Consultation Response from KC, Conservation & Design**2024/91057 and 2024/91136 - 82A, New North Road, Edgerton, Huddersfield, HD1 5NE****Installation of velux window to roof and solar panels to flat roofed extension (Listed Building within a Conservation Area)****Listed Building Consent for the installation of velux window to roof, solar panels to flat roof extension and internal alterations (within a Conservation Area)****Date Responded: 27.06.2024****Responding Officer: S Pickles****Responding Ref:**

PERSPECTIVE FOR ADDITIONAL VELUX ROOF LIGHT

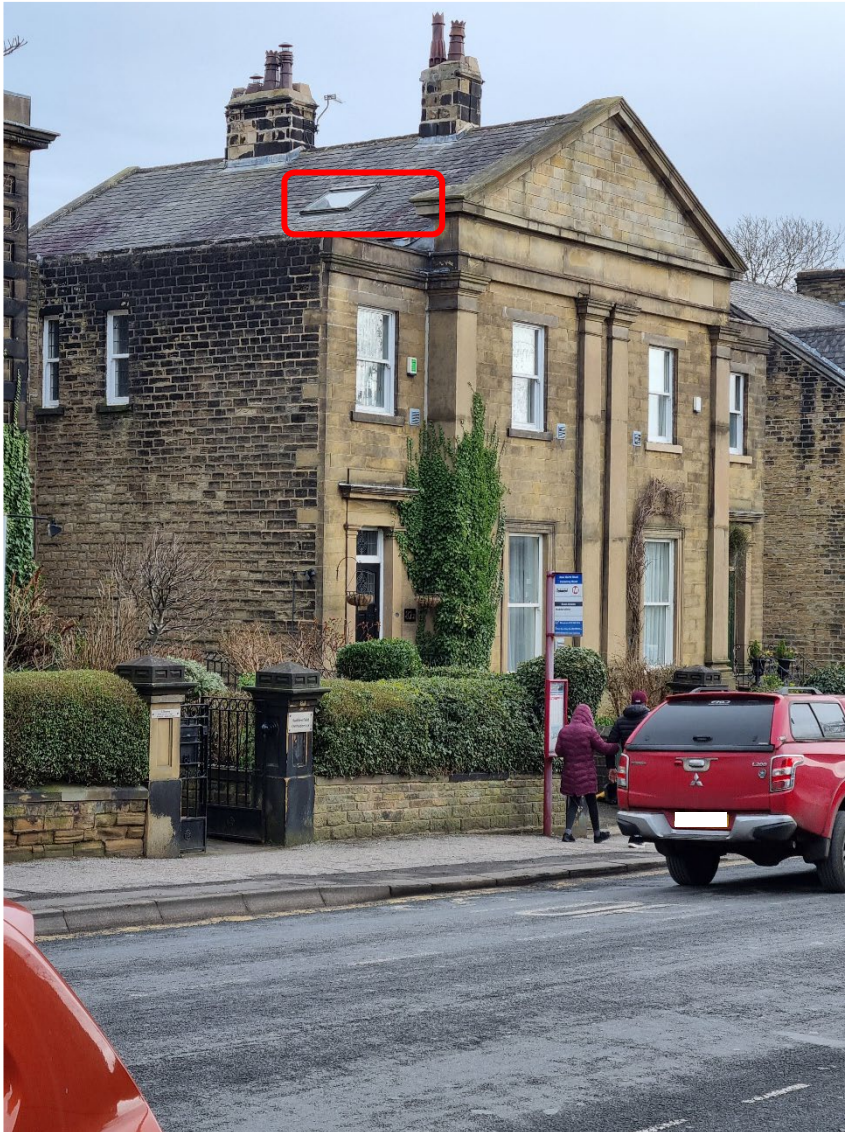
To the main roof it is proposed to add 1 roof light. There is an existing roof light slightly further back along the roof plane. On balance, we consider that the additional roof light is acceptable. There is visibility of the roof when looking off New North Road from the north, however, an additional roof light will not further harm the Listed Building.
